M25 Junction 28

Subject: Deadline 7 M25 Junction 28 - Our clients Mr and Mrs Jones Grove Farm (I.D 20025656)

Additionally we have submitted our comments to the consultation for the change 8 which we have reiterated below with some additional remarks.

**Fig 3.1 - HE Indicative alignment of amended Grove Farm egress (Change 8)**

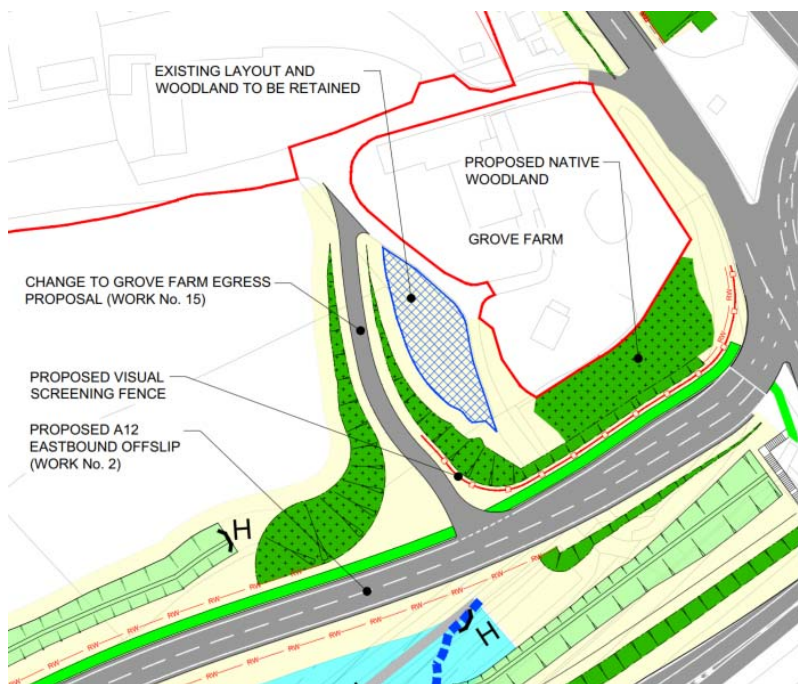
We note that there has been a change 8 submitted whereby the egress is moved westerly away from the main farmhouse by a further 25m. We welcome this amendment subject to appropriate landscape mitigation and noise attenuation barriers being constructed. It is acknowledged that the length of the egress will extend from 50m to 87m, but it will move traffic away from the farmhouse. We welcome the additional tree planting on both sides of the realigned egress and although long term could provide additional visual screening, this will not reduce the noise impact over the short to medium term while these trees mature over the next 15-20 years. Furthermore, trees do not provide noise attenuation unless a buffer of at least 100ft wide is planted with dense species and again the benefit of these would take an extended amount of time to be realised.

**Figure 3.2 – Grove Farm's suggested location for extra noise attenuation fencing**

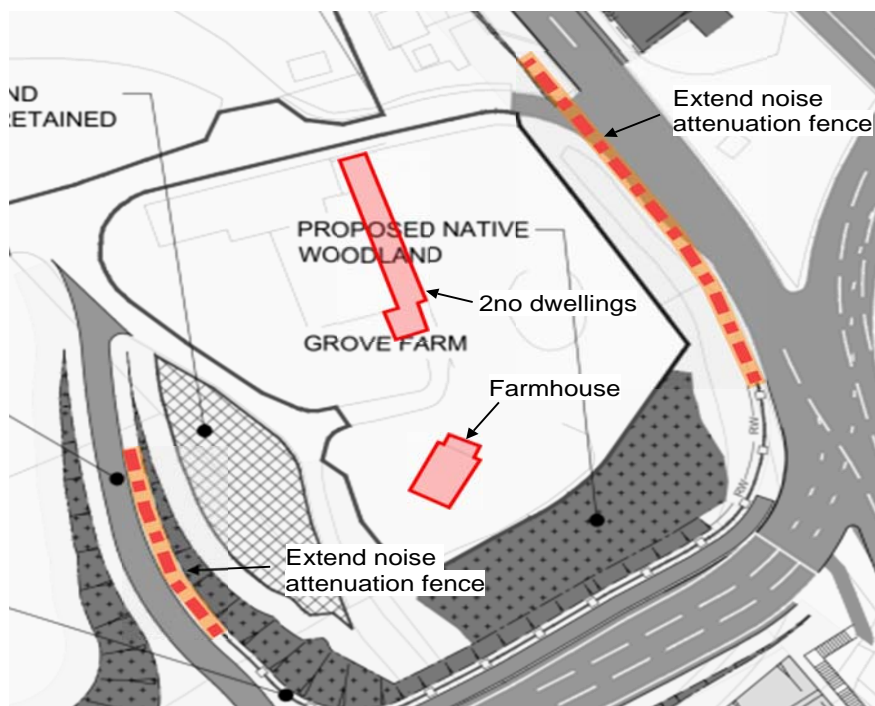
Grove Farm welcomes the response from HE with regards alteration of the farm egress onto the A12 eastbound off-slip. However, Grove Farm requests that the ExA should direct the HE to provide a noise attenuation barrier instead of the 'visual screen' currently proposed and extend the noise attenuation barrier further north on the M25 northbound on-slip and further north into the farm egress as shown on **Fig 3.2** within our submission at Deadline 6.

The 3m visual fencing will require substantial foundations to ensure these remain secure, incurring a cost as part of the scheme, however altering the barrier to noise attenuation will have a greatly positive benefit to the residents which will outweigh the increase in cost for this amendment.
